Appeal Decision

Appeal Ref: APP/R5510/W/23/3321565

10 Hartshill Close, Uxbridge, Hillingdon UB10 9LH

PROPOSED ELEVATIONS

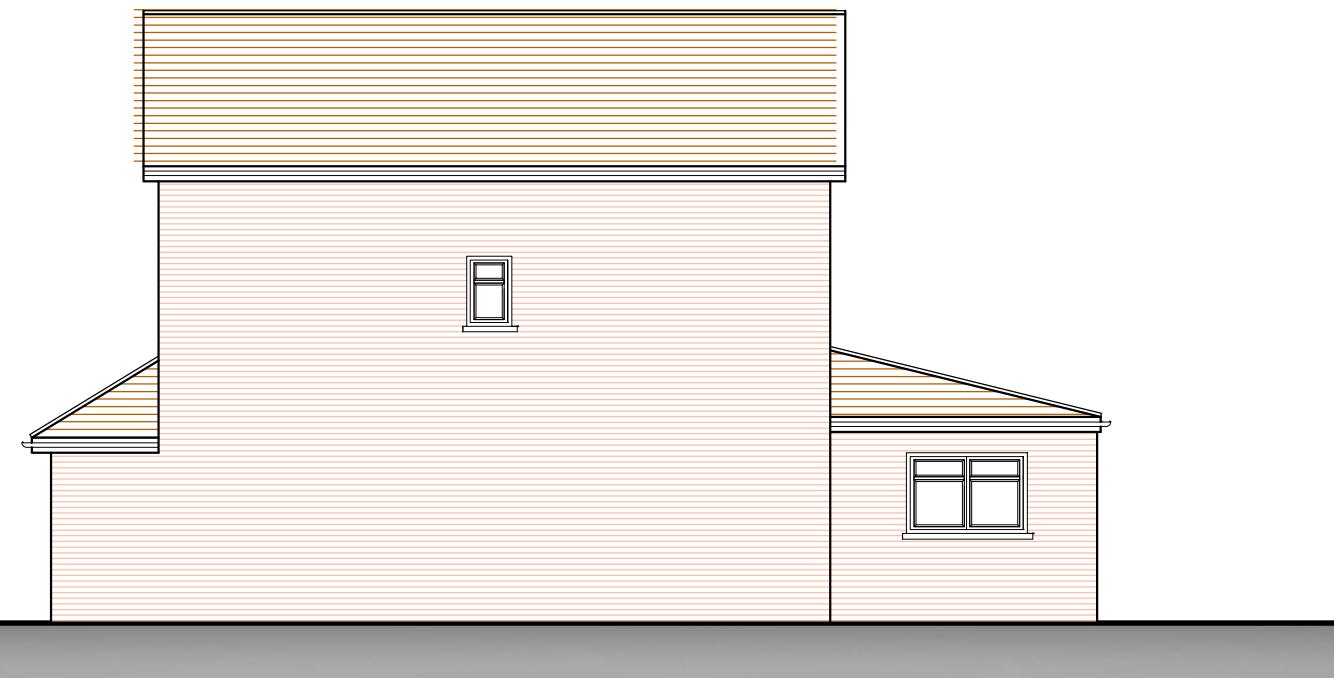
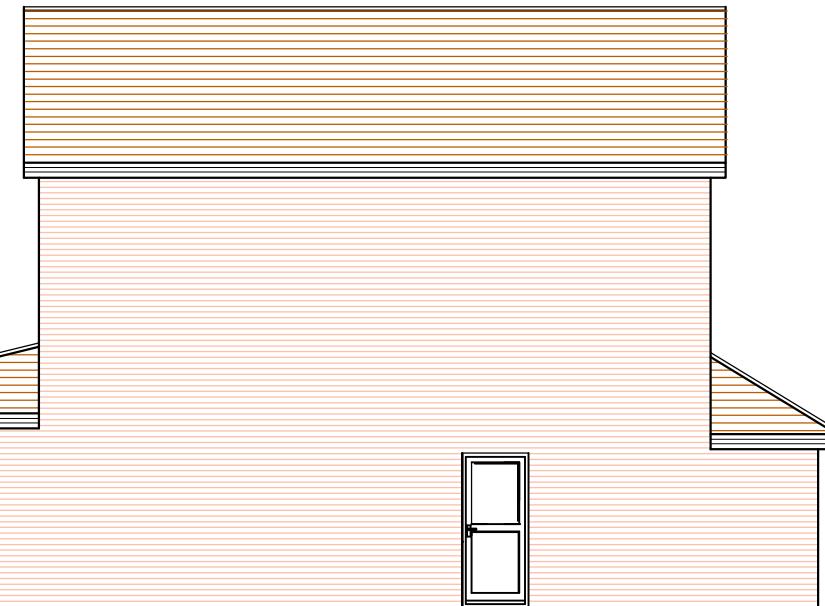
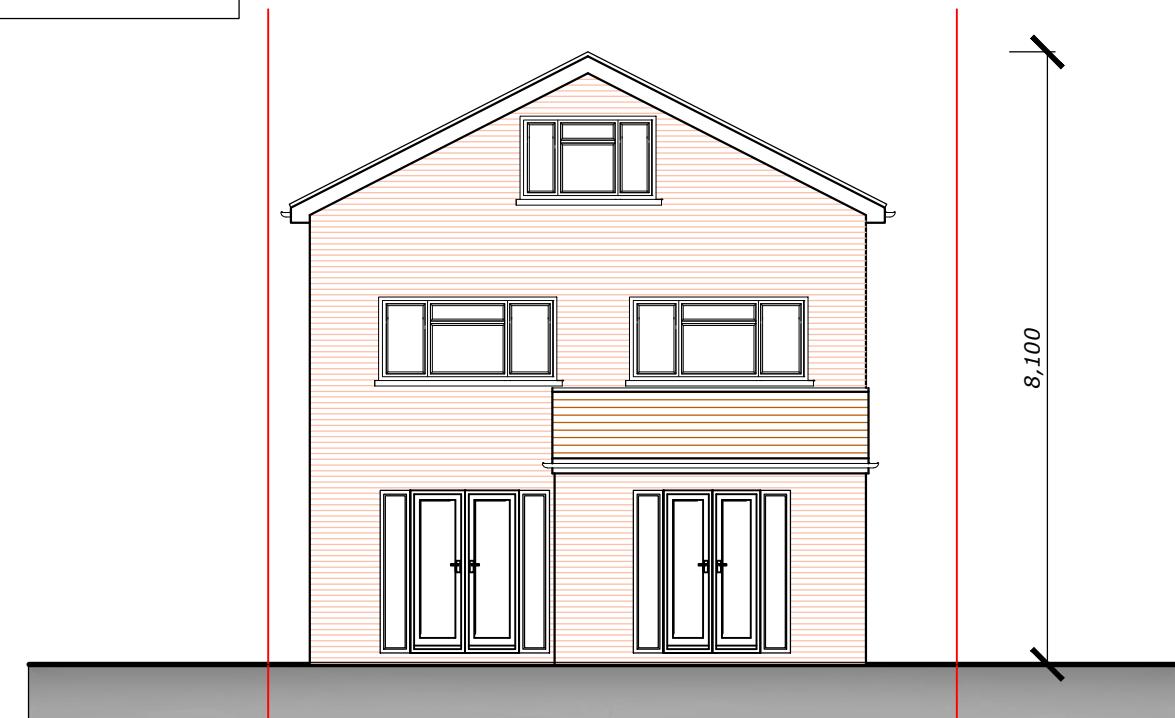
8. The proposal would raise both the eaves and ridge heights of the appeal property some 1 metres or so higher than they are currently, which would increase the amount of brickwork between the top of the first-floor windows and its eaves and ridge heights. Nevertheless, the proposal would see the same roof pitch retained and the modest increase in height would not unacceptably unbalance the appearance of the property or make it appear top heavy or particularly prominent, as it would retain its same broad form. For the same reasons, the proposal would sympathetically respect the design and architectural features of the property, including its principal elevation.

9. Whilst the proposal would make the appeal property higher than the properties nearby, including those with similar front facing gables, it would not be significantly higher. From its front elevation, there would be no openings at second floor level. In view of this, and the existing variety of the frontages of properties along Hartshill Close, the proposal would not appear out of scale with them, nor would it appear incongruous. Although there would be some effect on the regular pattern of the front facing gabled properties along this side of the road, due to the proposal's limited increase in height, and it being at one end of the line of this style of property, it would not harmfully disrupt this symmetry, when viewed in either direction along Hartshill Close.

13. In this case there are 2 no. existing bedroom windows on the rear elevation of the appeal property that already allow a degree of overlooking at oblique angles towards the gardens of the adjoining properties. The proposed second floor bedroom window would be above the existing first floor bedroom windows and would allow a similar level of overlooking also at oblique angles of the adjoining objector's garden. In view of this, the level of potential overlooking towards the objector's rear garden would not be materially different to the existing situation or be harmful to the living conditions of the adjoining occupiers. Consequently, I am satisfied that allowing this appeal would not unacceptably violate the nearby occupier's rights under the HRA and would be consistent with my PSED duty contained in Section 149 of the Equality Act 2010.

10. Consequently, I find that the external appearance of the proposal would be acceptable in terms of its effect upon the dwellinghouse and the area, and the proposal would accord with the requirements of paragraph AA.2.(3)(a)(ii) of Class AA of the GPDO. In addition, the proposal would comply with paragraph 130 of the Framework, that amongst other things requires development to function well and add to the overall quality of the area and be sympathetic to the local character.
